Application no: H08-0152-12

Description: Details of alternative window designs for front elevation (Condition 3 of H08-0493-09)

Location: 1 Spalding Road
Gosberton
Spalding
PE11 4NP

Amendment: Revised window detail (dwg. no. 11/289/PA/007)

Drawing No. 11/289/PA/007

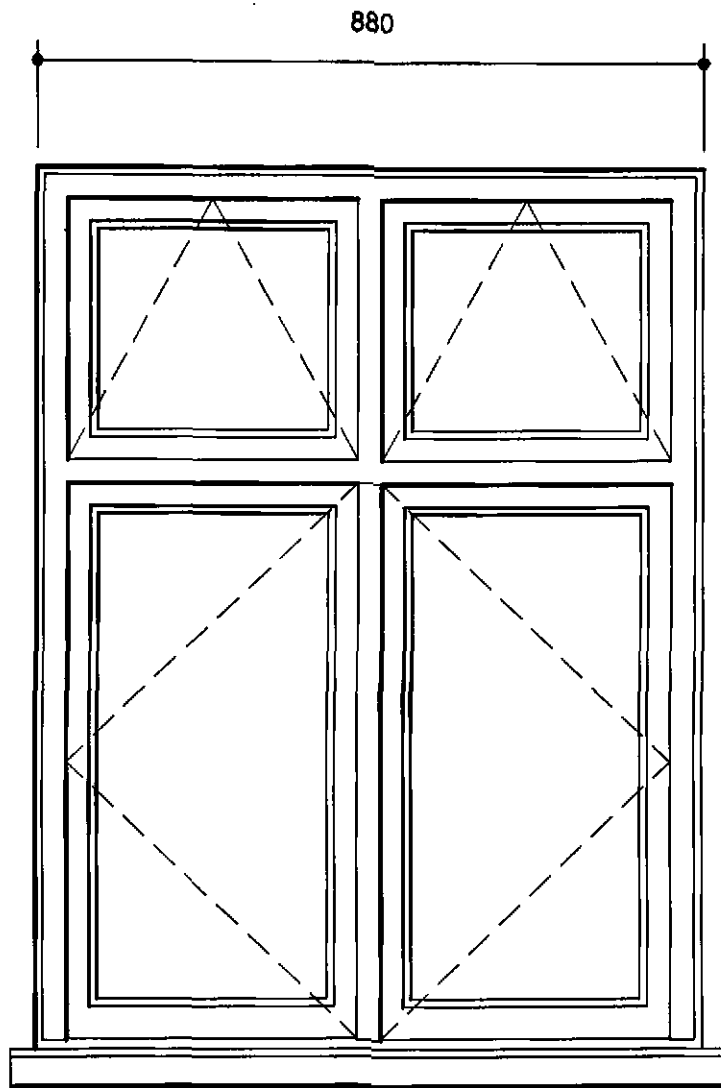
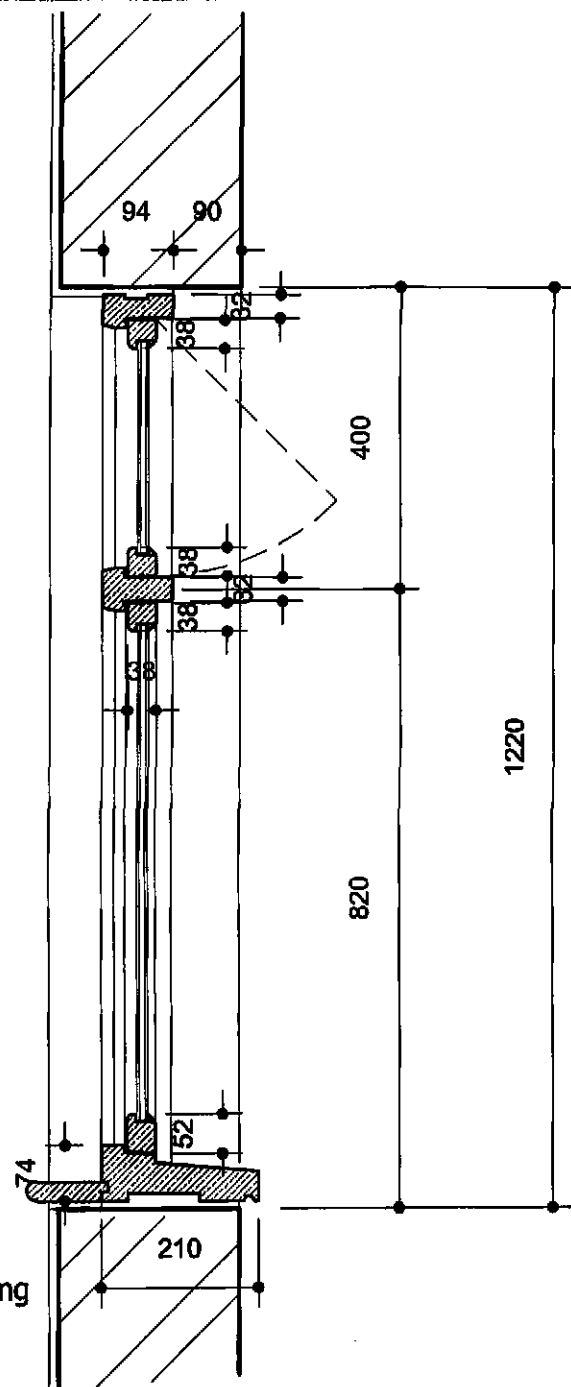
I'm not going to get drawn into too lengthy a debate on this, having already rehearsed the issues several times over with previous agents. I'm aware that the property isn't listed or within a conservation area, but for all that it is still a sizeable, traditional building that has a significant presence at the main entrance to the village and can quite easily be assessed as a non-designated heritage asset in the context of PPS5. In addition to that Local Plan policy SG20 makes clear that alterations to existing buildings should 'not detract from the character, appearance or historic significance of the building'. I'm afraid that I find myself unable to support the revised detail you have attached to your email, and think it likely that any application made on this basis would be refused. I can only suggest that your clients accept the need for replacement windows of traditional design and detailing- both in terms of the frame sections, moulding and manner of opening. As far as reaching a compromise goes, I have to say that in allowing the use of PVCU to the rear, and having indicated that replacement chimneys will not be required, I think the Council has extended its discretion as far as it can go.

I have taken on board the comments you made previously, and have cropped off the casement overlaps to the fixed part of the frame. I have also extended the width of the fixed elements of the frame so that the opening lights sit within the rebates of the fixed frame. The top lights have been divided into two independent top-openers, but I have a technical difficulty with doing the same with the bottom lights, since we have to create fire escape both to meet the Building Regulations, but chiefly so that we are not responsible for burning people.

I would like to reach a compromise with you and create a whole-pane top opener for the bottom light. I can include a dummy "fixed" mullion to maintain the effect of a cruciform window, but need to open the whole window to allow emergency egress.

Sorry about my frustration yesterday. I have done a little research and now attach a revised drawing that I suspect will be closer to that which you were seeking. Please let me know.

I attach my revised drawing for substitution with that previously submitted with the recent Condition Compliance application please. I trust that an approval will now be forthcoming since the detail submitted is in line with that previously approved, but with bottom lights to suit the requirements of Building Control.
